Approval of details reserved by condition imposed under AW/228/21/RES relating to conditions 8-bird and bat boxes, 10-EV charging and 11-energy efficiency.

36 Carlton Avenue Aldwick PO21 3LR

Arun District Council have decided to **APPROVE details reserved by this condition**

CLIENT	Counterpoint Properties Ltd	
SITE	Carlton Avenue, Rose Green, West Sussex	
PROJECT	Proposed Development Comprising 8 Dwellings	
DRAWING	003 Parking Plan	
DATE	29 07 21	
AUTHOR	AH	REVISION A - 13 08 21 Garages
STATUS	PL	
SCALE	1: 500 @ A3

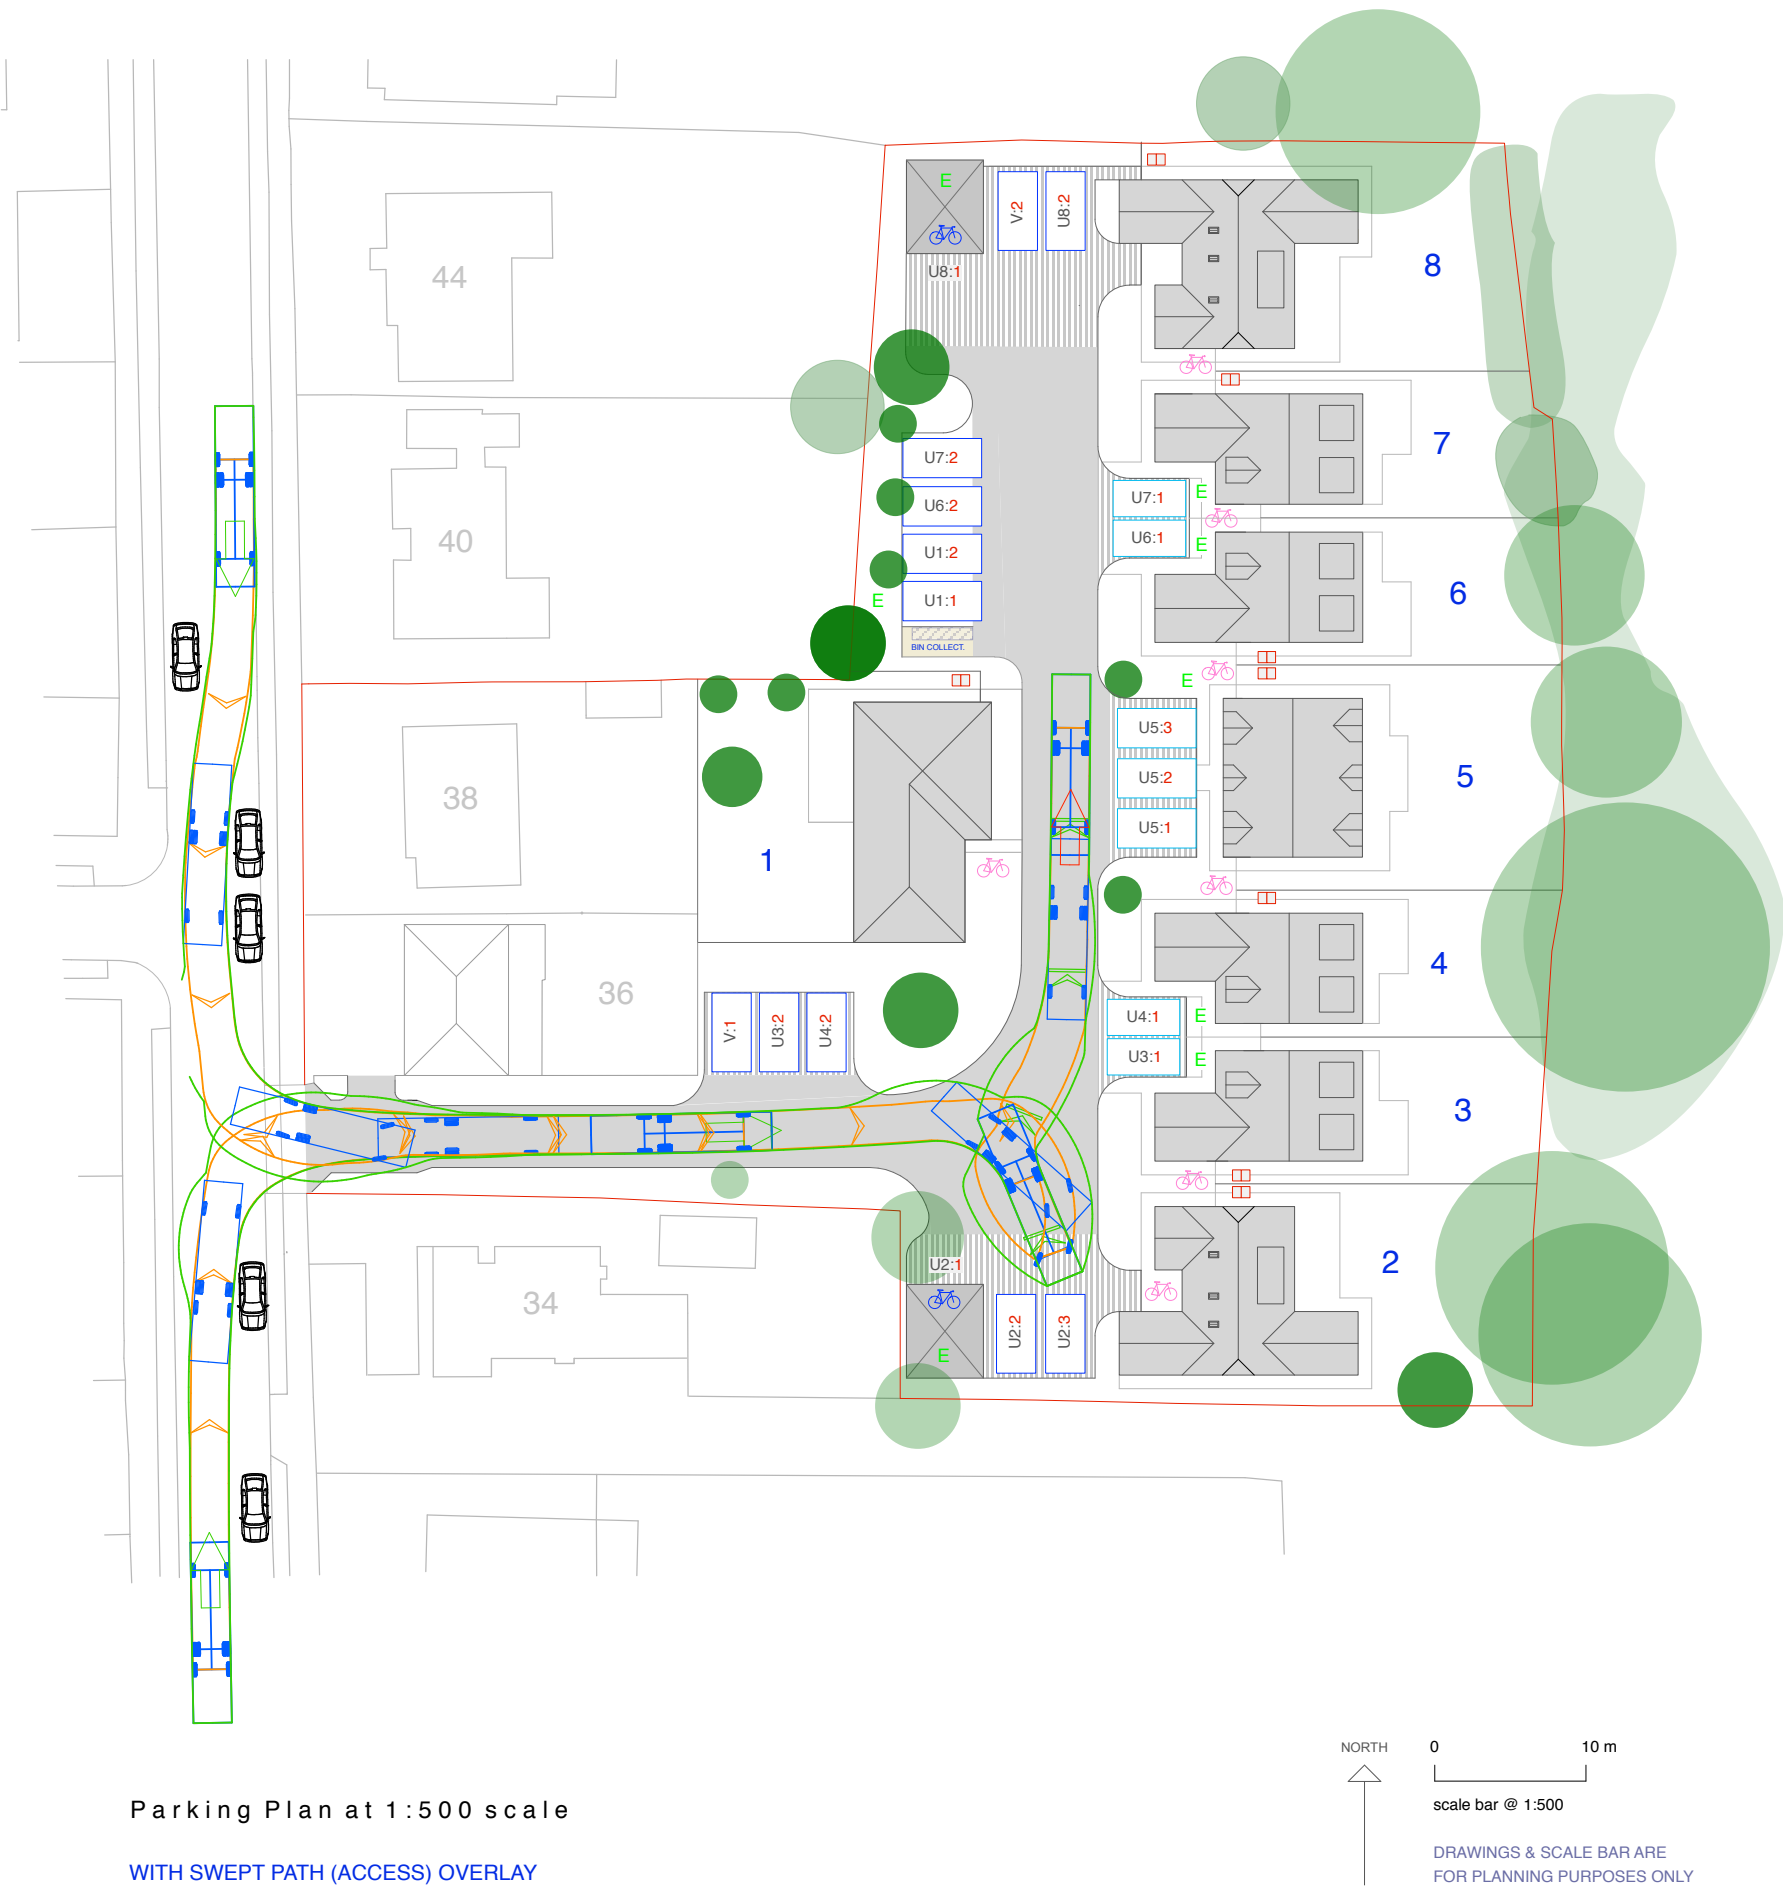
The proposed EV charging provision has been assessed and found to be acceptable. The condition is discharged on the basis that the development is constructed and maintained in accordance with the following details:

- Parking Plan 003 REVA
- EV Charging Statement
